January 11, 2016

Mr. Travis Saunders, Senior Planner  
Development Service Group  
City of Mercer Island  
9611 SE 36<sup>th</sup> Street  
Mercer Island, WA 98040

**RE: Review of 5637 Mercer Way – December 11, 2015 Revised Critical Areas Report**

**Wetland and Wetland Buffer Impact Site Plan**

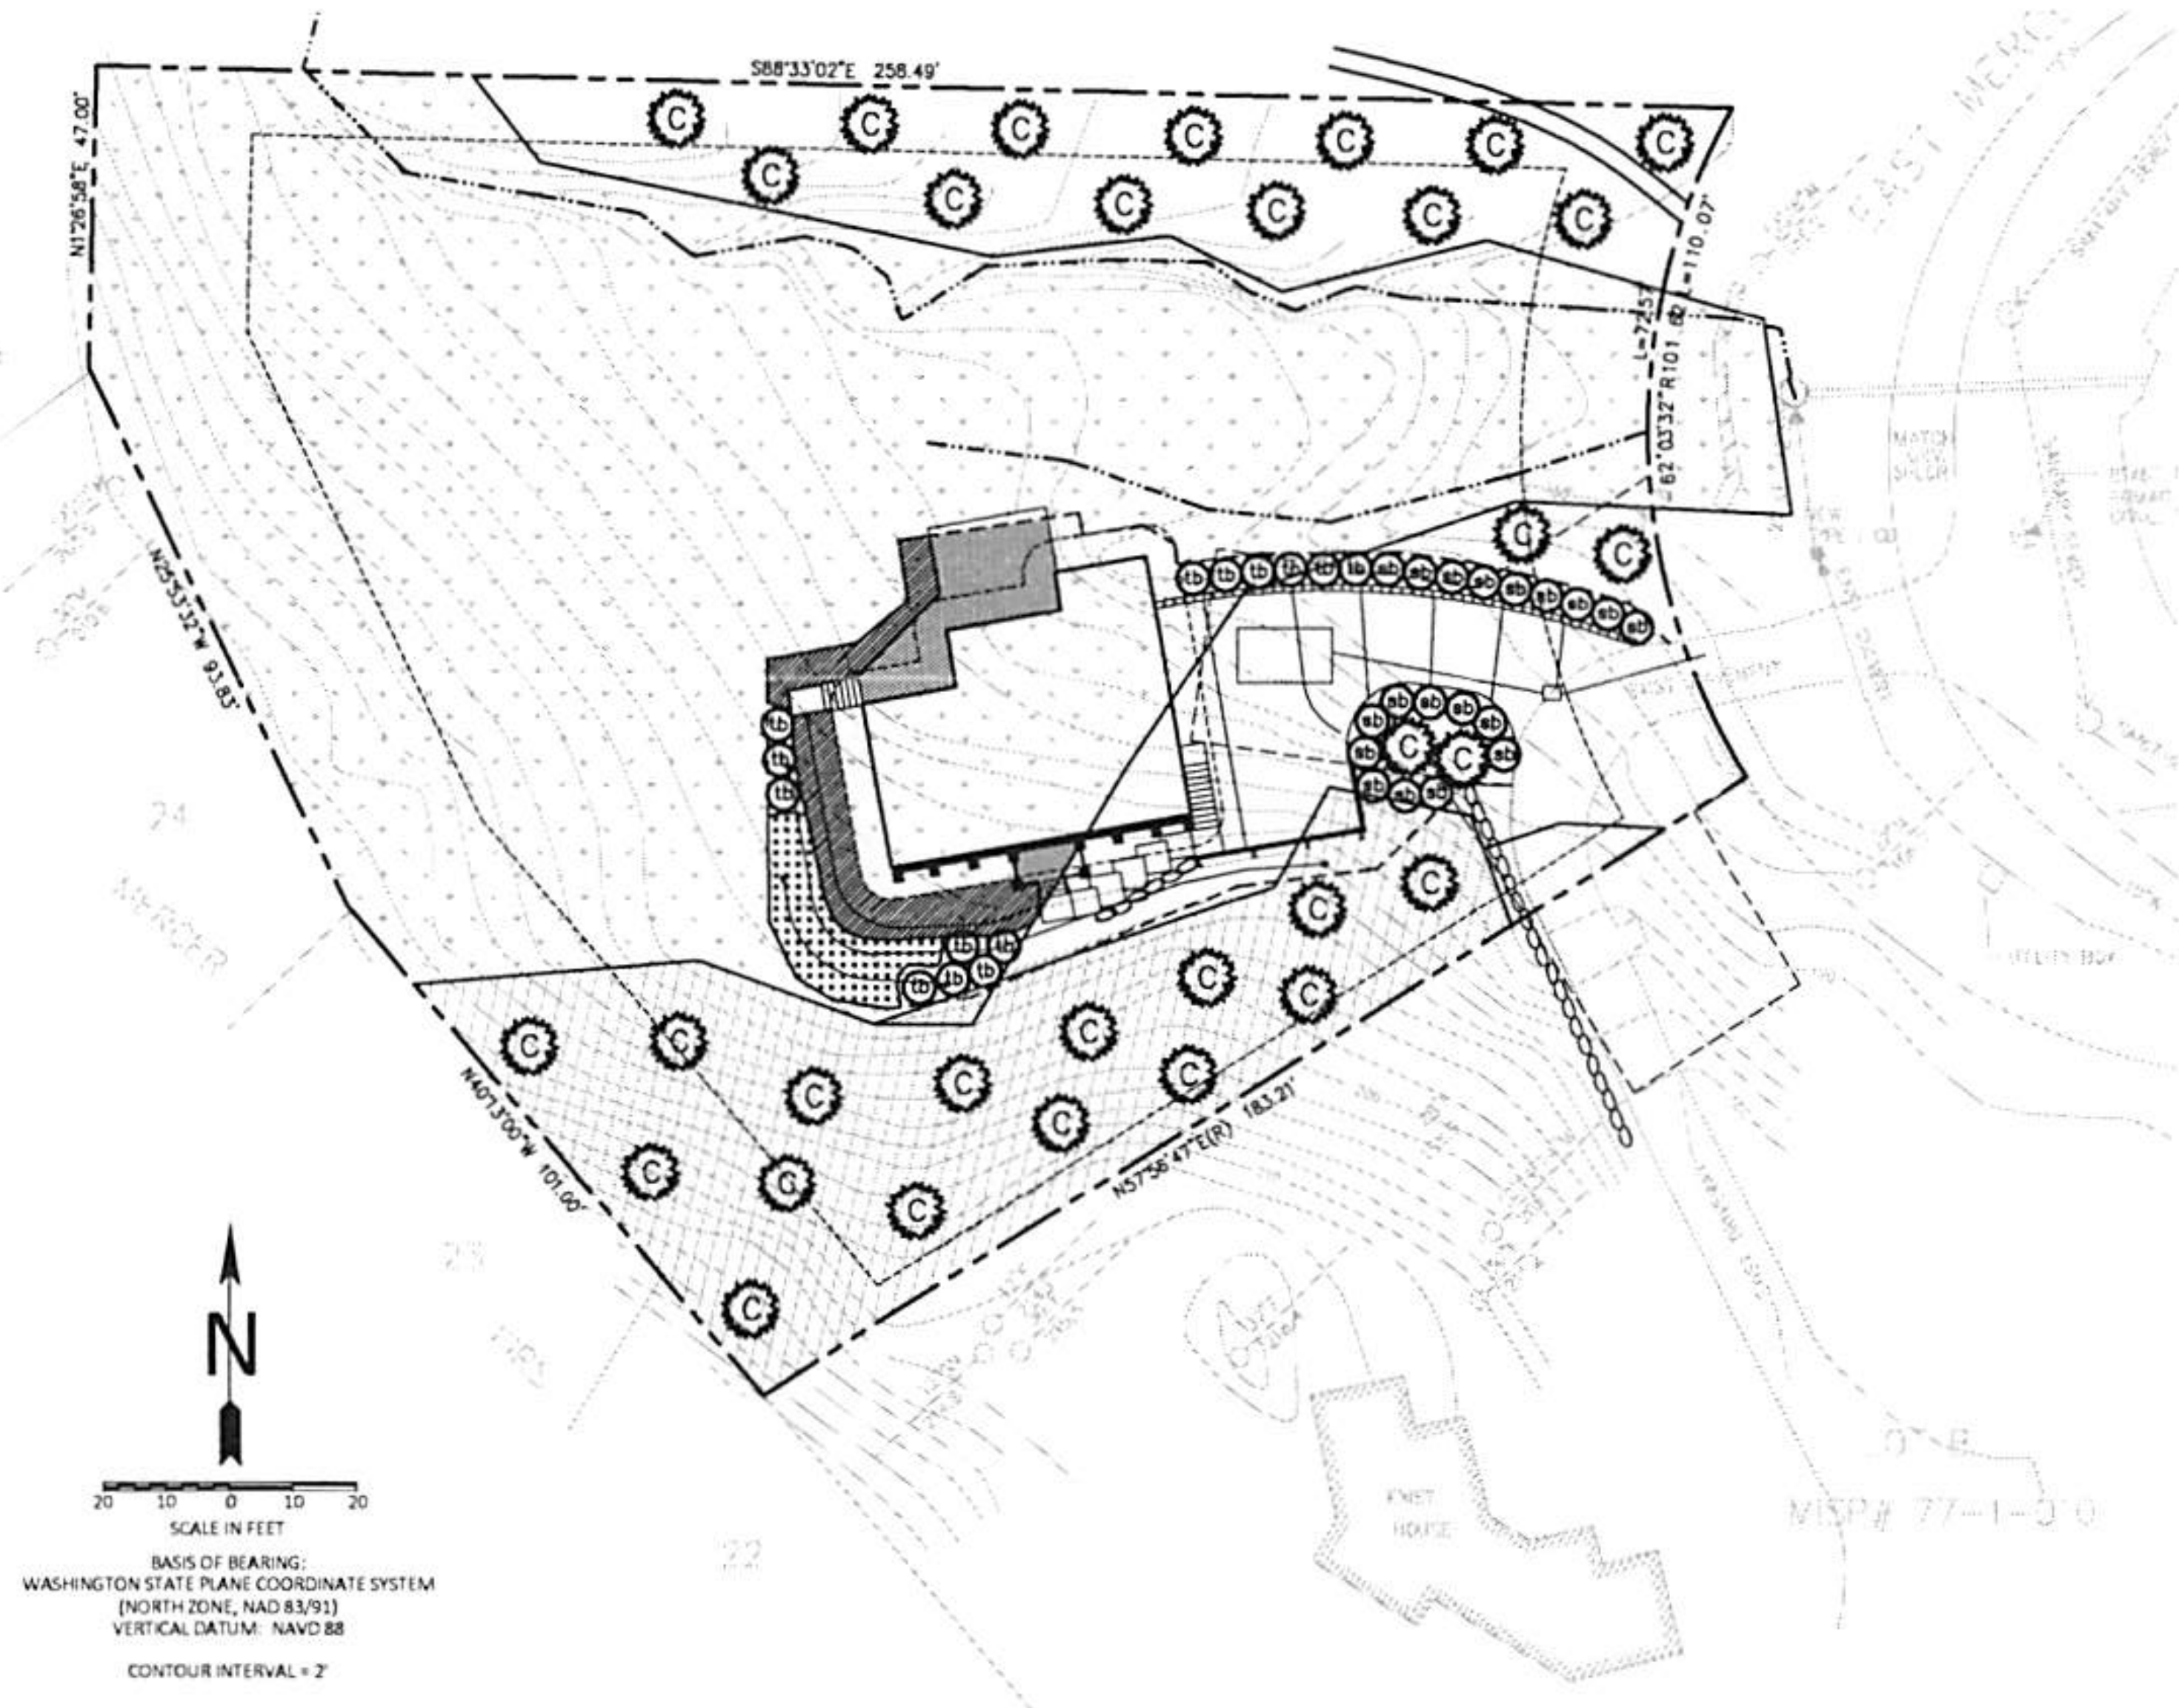
The applicant proposes to build a house on pin piles; however, the foundation of the house would rest on the soil surface or require excavation and would likely be considered fill within Wetland A. Based on project plans submitted with the March 5<sup>th</sup> Revised CAR, it appears the wetland will be filled due to construction of basement walls, basement stairs, a garage floor slab, a driveway, the front entrance to the house, and retaining walls.

Wetland A is rated as a Category III wetland and requires a 50-foot standard buffer (MIMC 19.07.080C(1)). This buffer can be reduced to 25 feet when buffer enhancement is implemented. Even if buffer reduction were to occur, the development would still impact portions of the wetland buffer (impacts due to the structure, stairs, driveway, and retaining walls).

The proposed house would not directly impact either of the Type 2 streams; however, the proposed development is located within the 50-foot buffer of Stream B. The stream buffer may be reduced to 25 feet when buffer enhancement is implemented; however, multiple portions of the development (includes structure, driveway, and retaining walls) would still be located within the reduced buffer.

To mitigate for 3,120 square feet of permanent buffer impact, the applicant proposes to plant conifers "...throughout the wetland in an area equal to the area of the coverage by the project within the critical areas, to enhance the plant community within this wetland as well as removal of any blackberry and English ivy in the vicinity of the home." Planting conifers (60, 2-gallon plants) and invasive species removal will provide ecological lift primarily to habitat functions and the proposed wetland enhancement appears to provide sufficient functional lift to the wetland to offset permanent buffer impacts. MIMC does not provide guidance for buffer mitigation.

An area 5 feet wide around portions of the development will be temporarily impact 1,900 square feet of wetland and buffer and will be restored with a mix of native shrubs following construction. MIMC 19.07.080 does not directly address mitigation of temporary wetland and buffer impacts; however, the applicant's mitigation approach to these impacts appears adequate and in-line with other local jurisdictions that require mitigation for temporary impacts.

As part of the final CAR submission to the City, the applicant should provide an impact figure that visually represents impact areas at the project site.
